From: Anita Gardner
Sent: 20 July 2017 15:32
To: Planning.Responses
Subject: FW: THE LITTLEHAMPTON ACADEMY - PLANNING APPLICATION - LU/183/17/PL

Please scan as additional information from agent relating to fencing colour

Hi Mark,
You will need to provide a new revised Proposed Fencing Elevation.
Regards
Anita

TITLE SALES DRAWING FOR EUROGUARD
PLATFORM HEAVY FENCING 2.43m HIGH
CUSTOMER
Drawing No.
10 J6/01061
ACK No.
Sheet 2 of 2

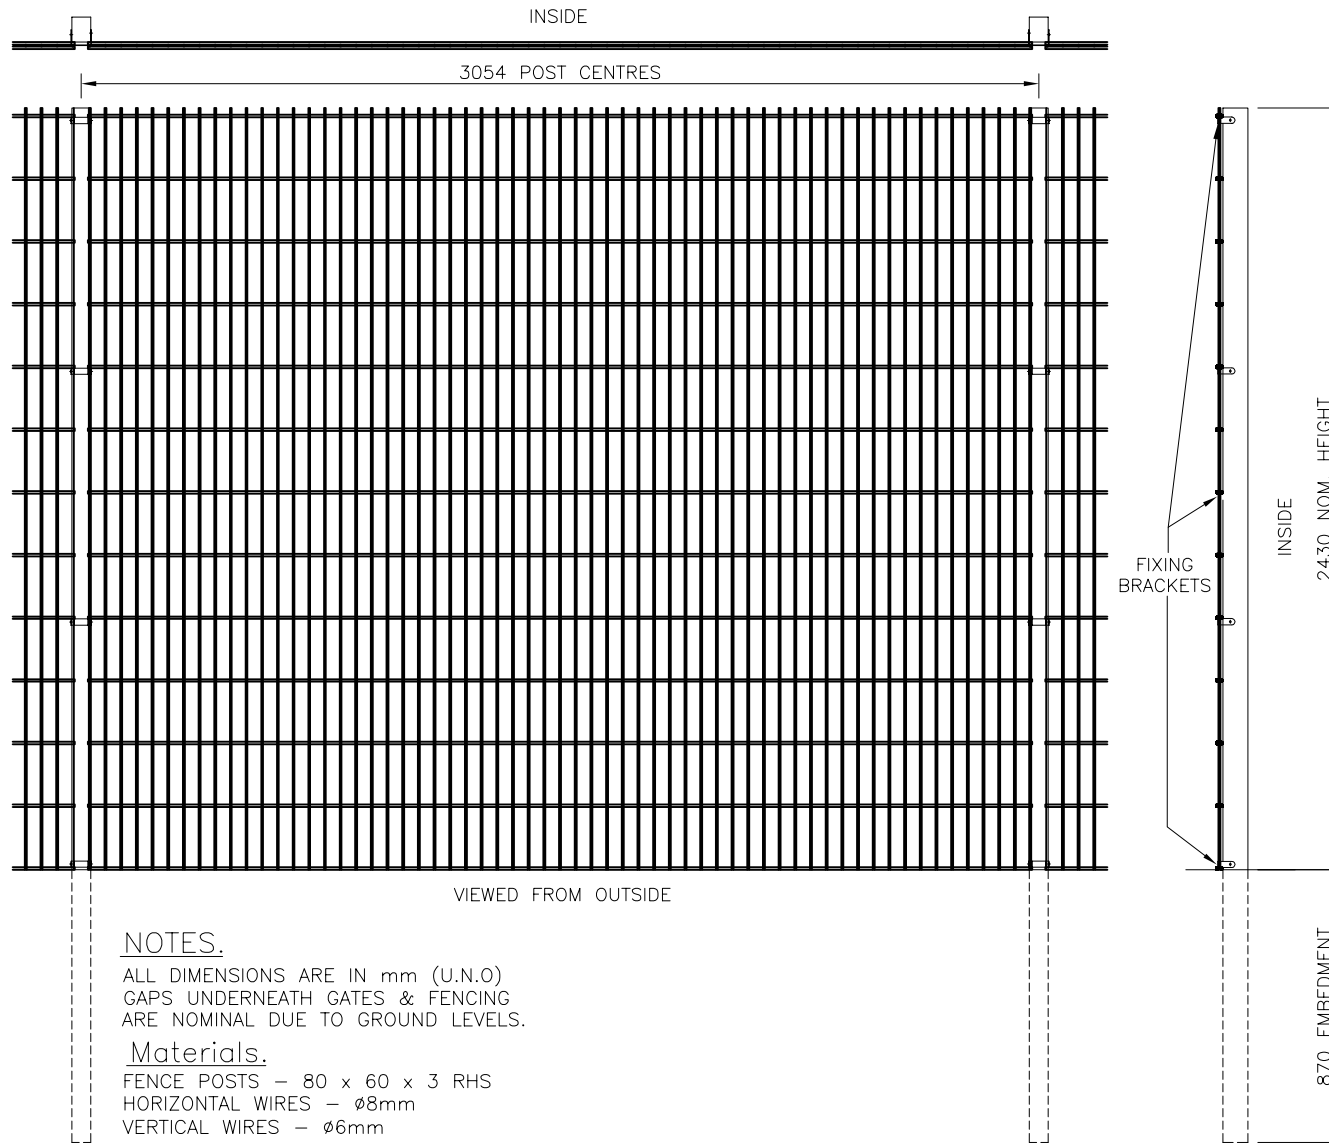
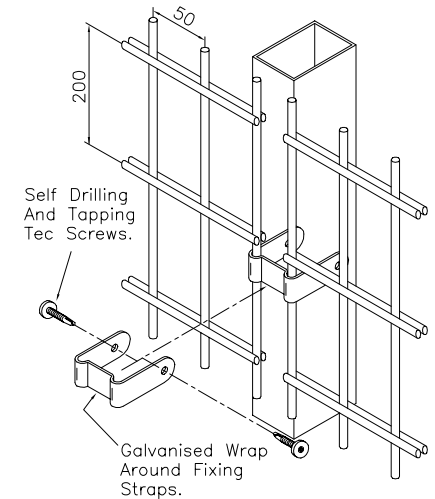
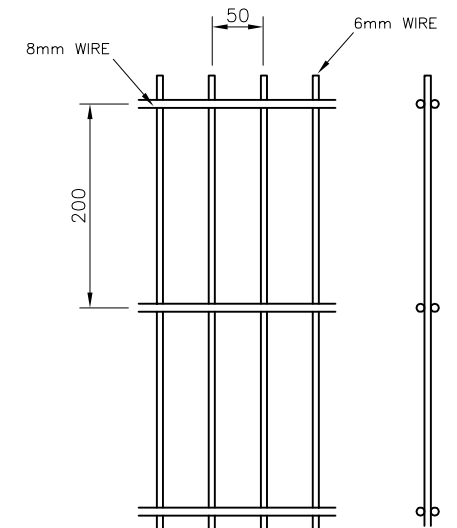
Please can you confirm what information this detail supersedes? Is it just the Jackson Fine Fencing Detail or is it also the Proposed Fencing Elevation? If so I will need another revised elevation. I would also appreciate confirmation of the colour. Is it proposed to be black to match existing?

The elevation will look the same, there is a slight difference in the gauge of the wire from 6/8mm to 5mm.

The detail at the top is slightly different also as per the attachment I sent over.

The fencing will still be black to match existing.
